21 December 2010

**MP 09\_0206 PREFERRED PROJECT REPORT  
RAS EXHIBITION HALL UPGRADE AT SYDNEY OLYMPIC PARK**

We refer to the above Major Project MP 09\_0206 for the Royal Agricultural Society (RAS) Exhibition Hall Upgrade at Sydney Olympic Park. JBA Urban Planning Consultants have been engaged by the Royal Agricultural Society of NSW (RAS) to prepare the Preferred Project Report for MP 09\_0206.

Drawing Title
NORTH ELEVATION

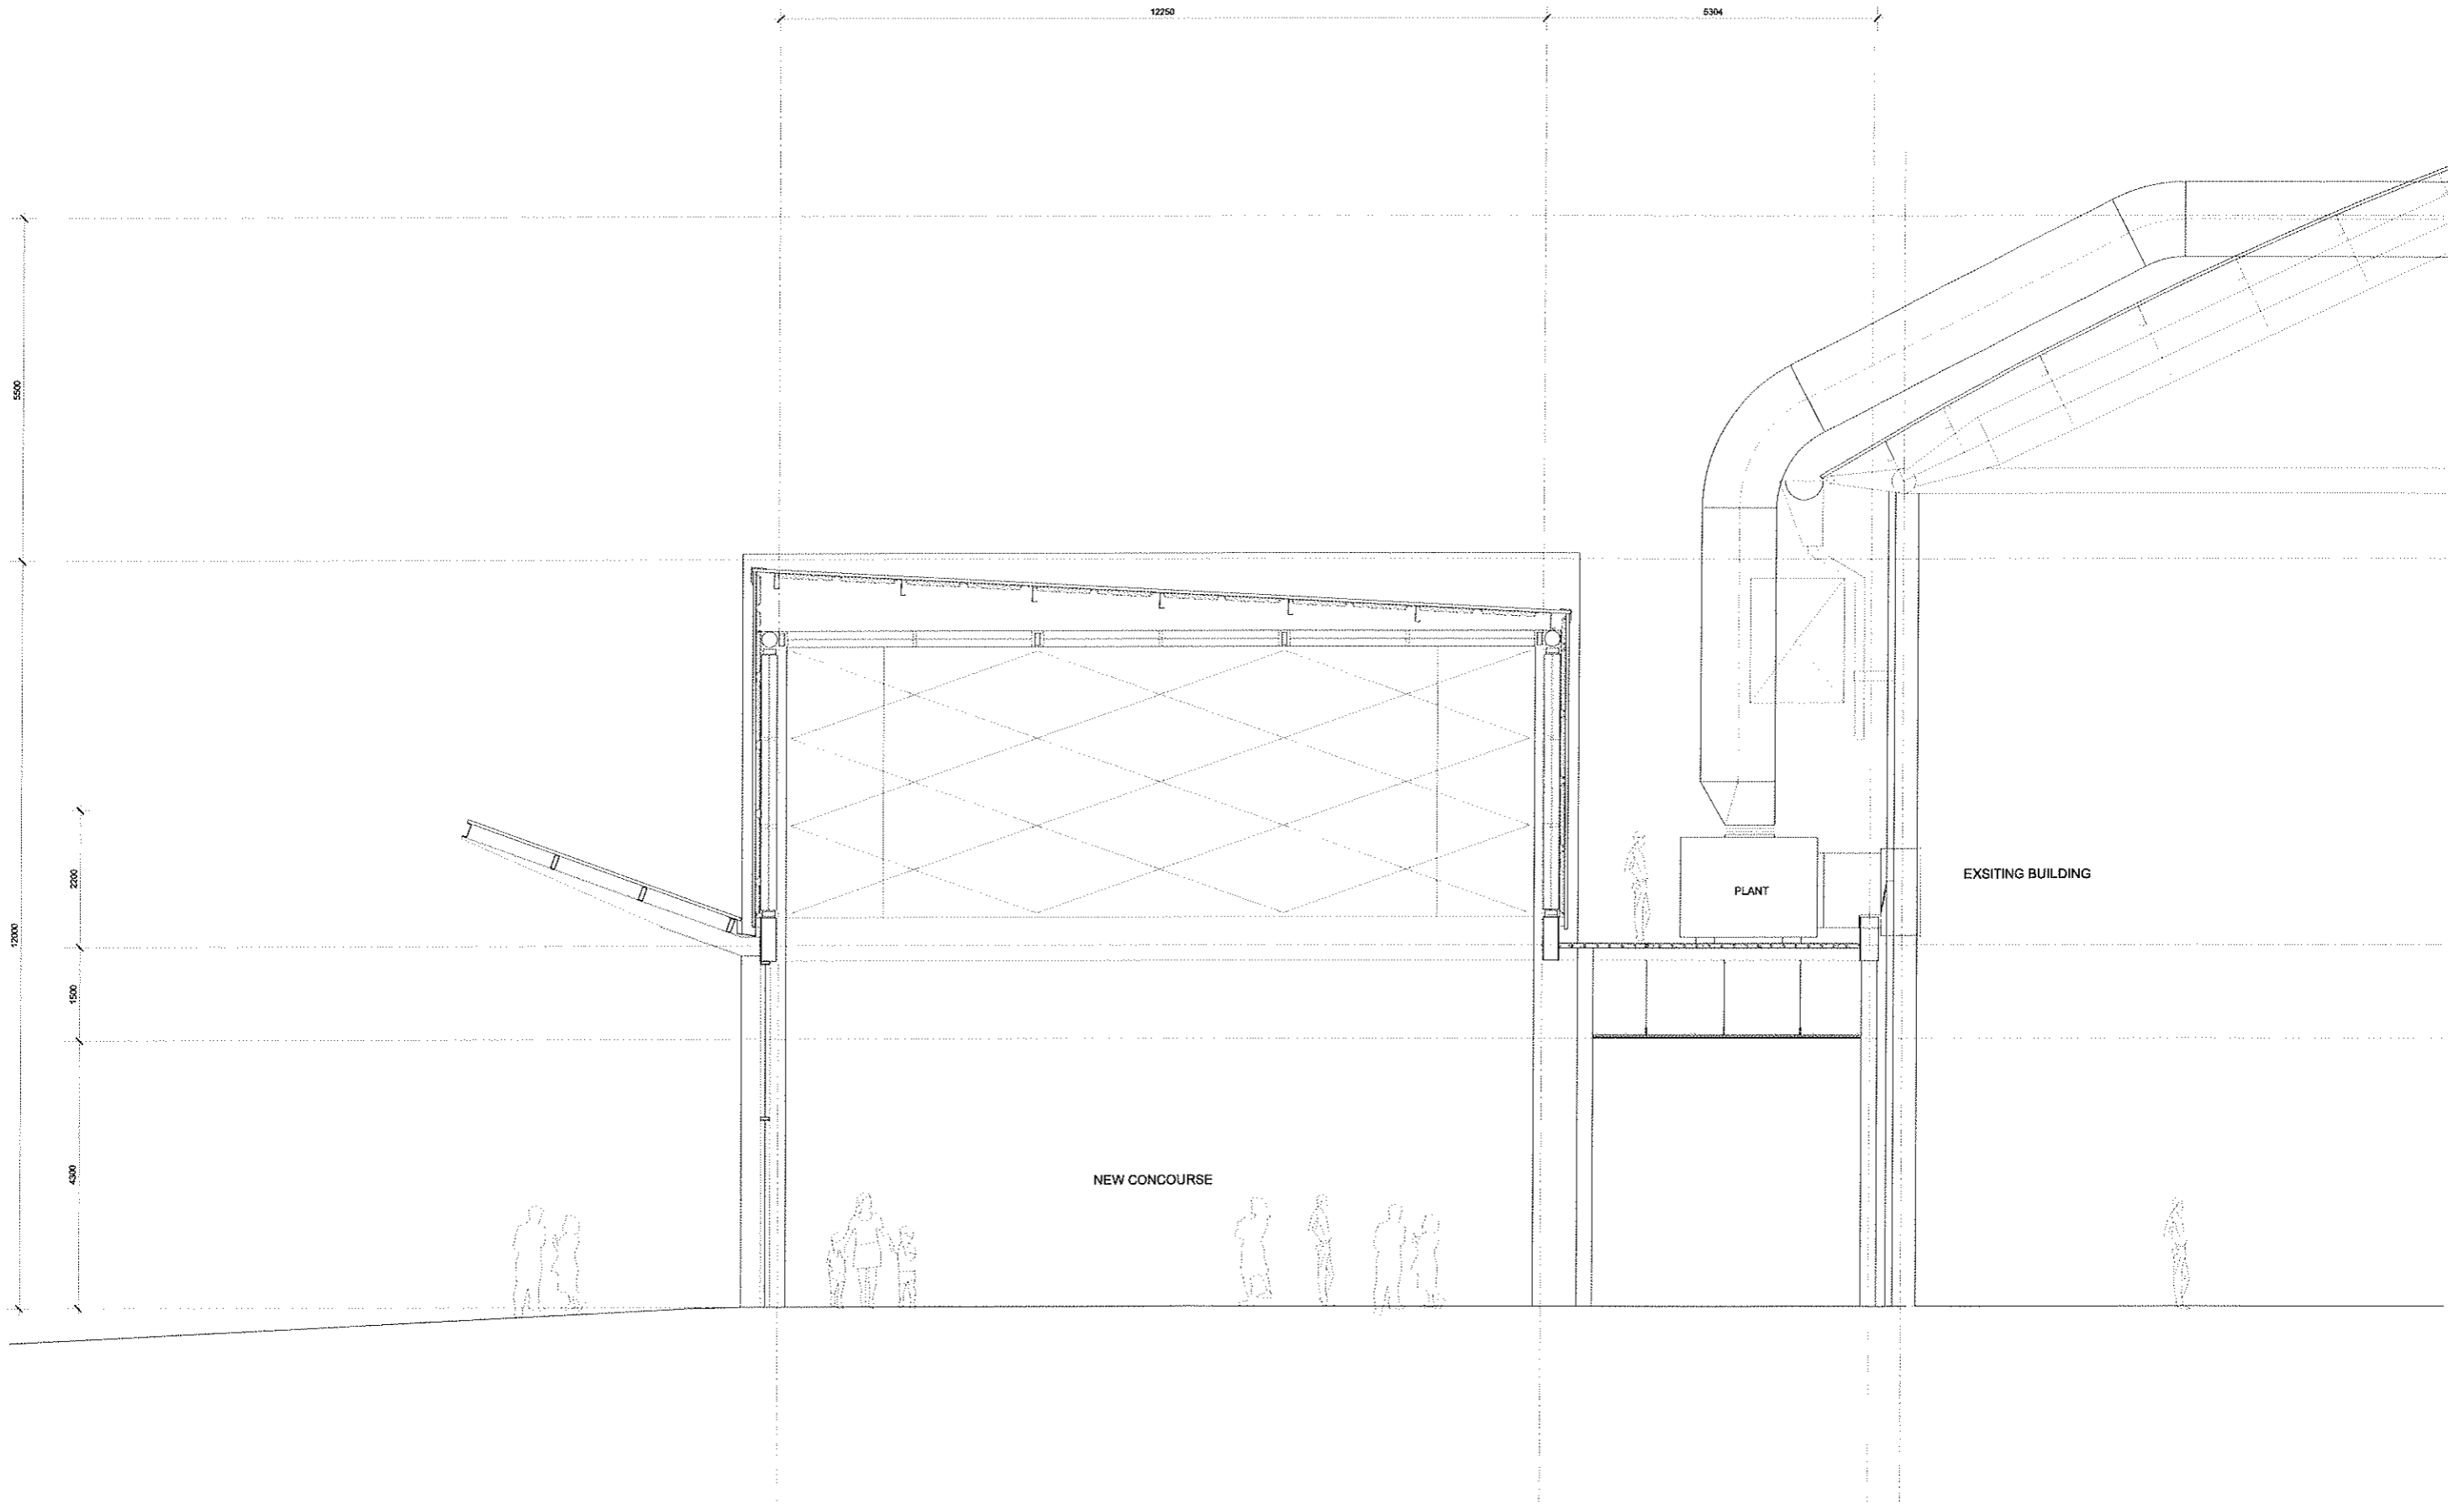
The SOPA submission raised concerns regarding the locations and penetration of duct work through the existing roof, and requested that a mechanical ventilation report be prepared as part of the Preferred Project Report. SOPA requested that the report include a review of the ducting system and include feasibility of alternate options, resulting in fewer ducts over the building eave.

Cox Richardson Architects advises that the following design parameters were set in discussion with the RAS and SOPA to drive an appropriate design solution for the exhibition hall air conditioning options:

Due to the existing operable doors, the new duct work is prevented from entering from the side of the building, and must run external to the building before entering above the door rails. Furthermore, future works as part of the overall redevelopment of the Showgrounds will hide the new duct work.

In line with the comments and suggestions made by AMW, the design of the roof ducts has been amended such they are reduced in number and will be less visible from the surrounding public domain.

Drawing Title: PART 3A SUBMISSION  
DA\_005 NORTH ELEVATION  
Scale: 1:500, 1:100  
Date: 17.03.2010 [02]

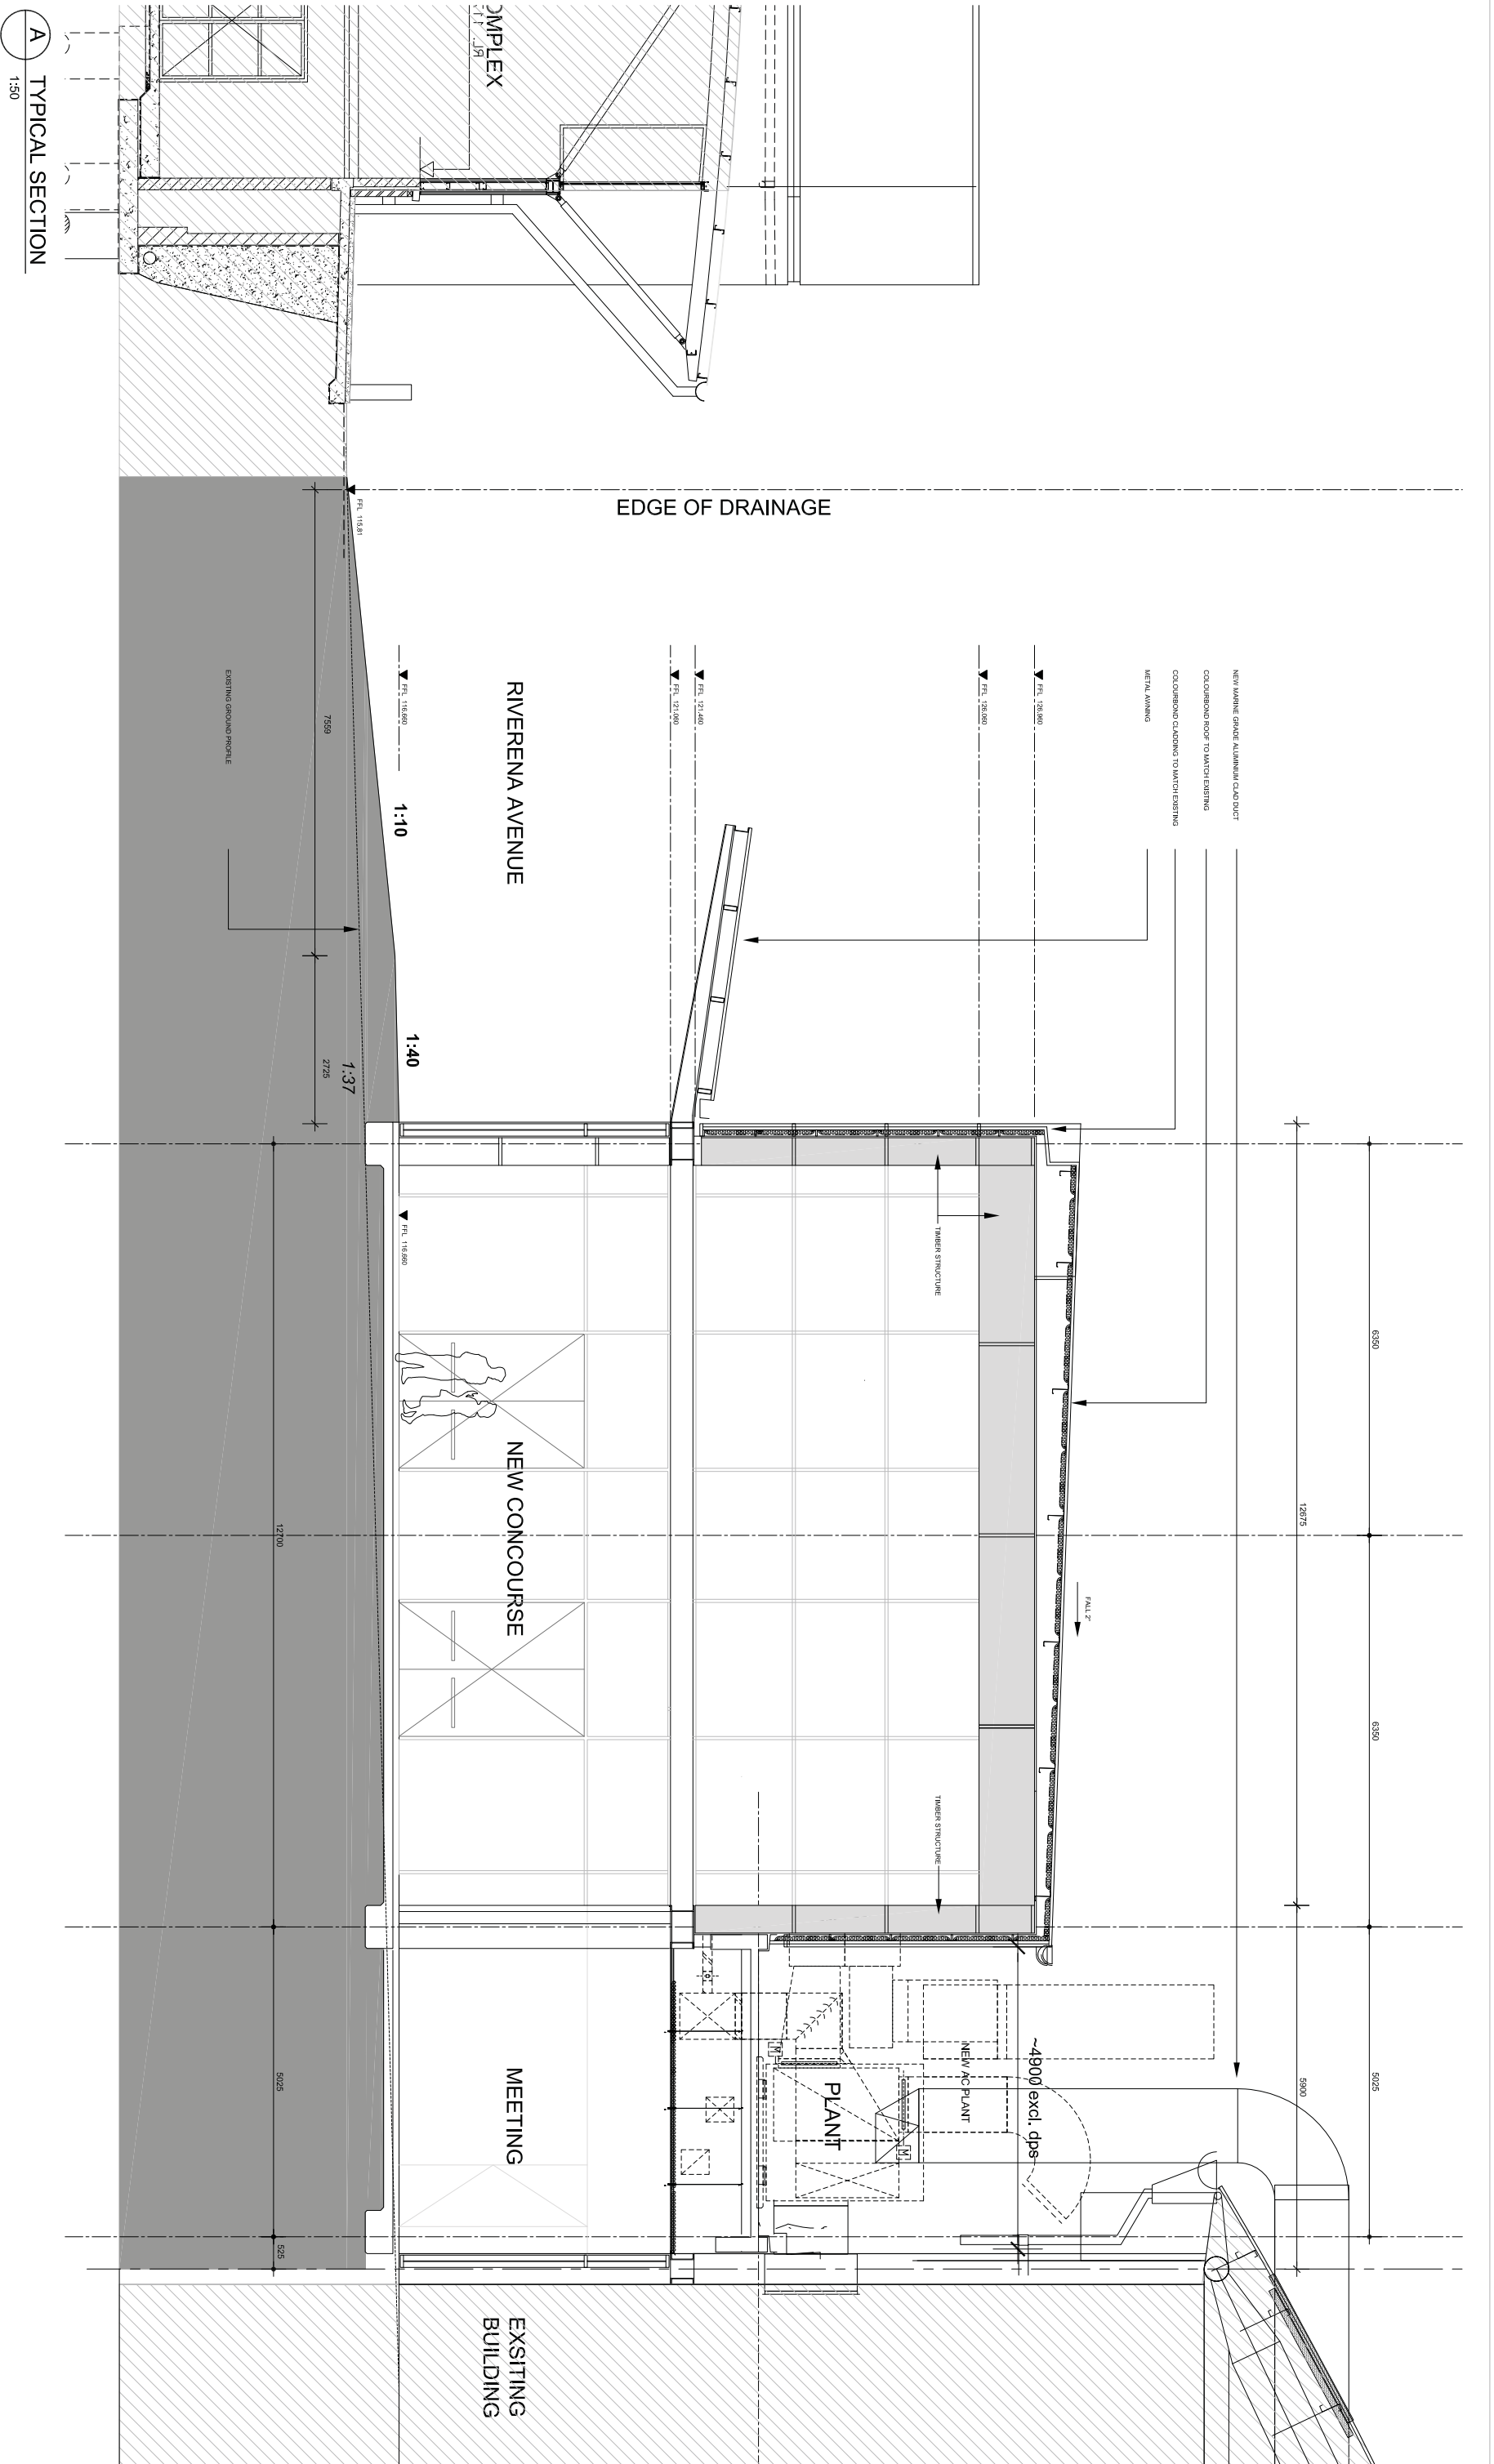
1. *The proposed awnings and entry canopy, which appear highly polished and contemporary, and out of character with the more rustic 'shed' language of the existing buildings. Consideration may be given to alternative material and profiles for the new awnings and entry canopy.*

2. *The width of the proposed awning along the north-west facade is modulated in Plan, and appears very narrow at points. Continuous sheltered pedestrian access along the facade should be considered.*

The materials proposed have been amended such that the soffit of the awning will now be finished in timber.

The awning provides sun control to the facade and at its narrowest provides horizontal cover for the 2725mm wide level accessible walkway which runs along the entire building facade.

It is noted that the existing awning is modulated and that the wider sections of the awning are located at points where people will access the building and therefore affords appropriate weather protection. The new concourse will provide shelter for people walking between the halls.
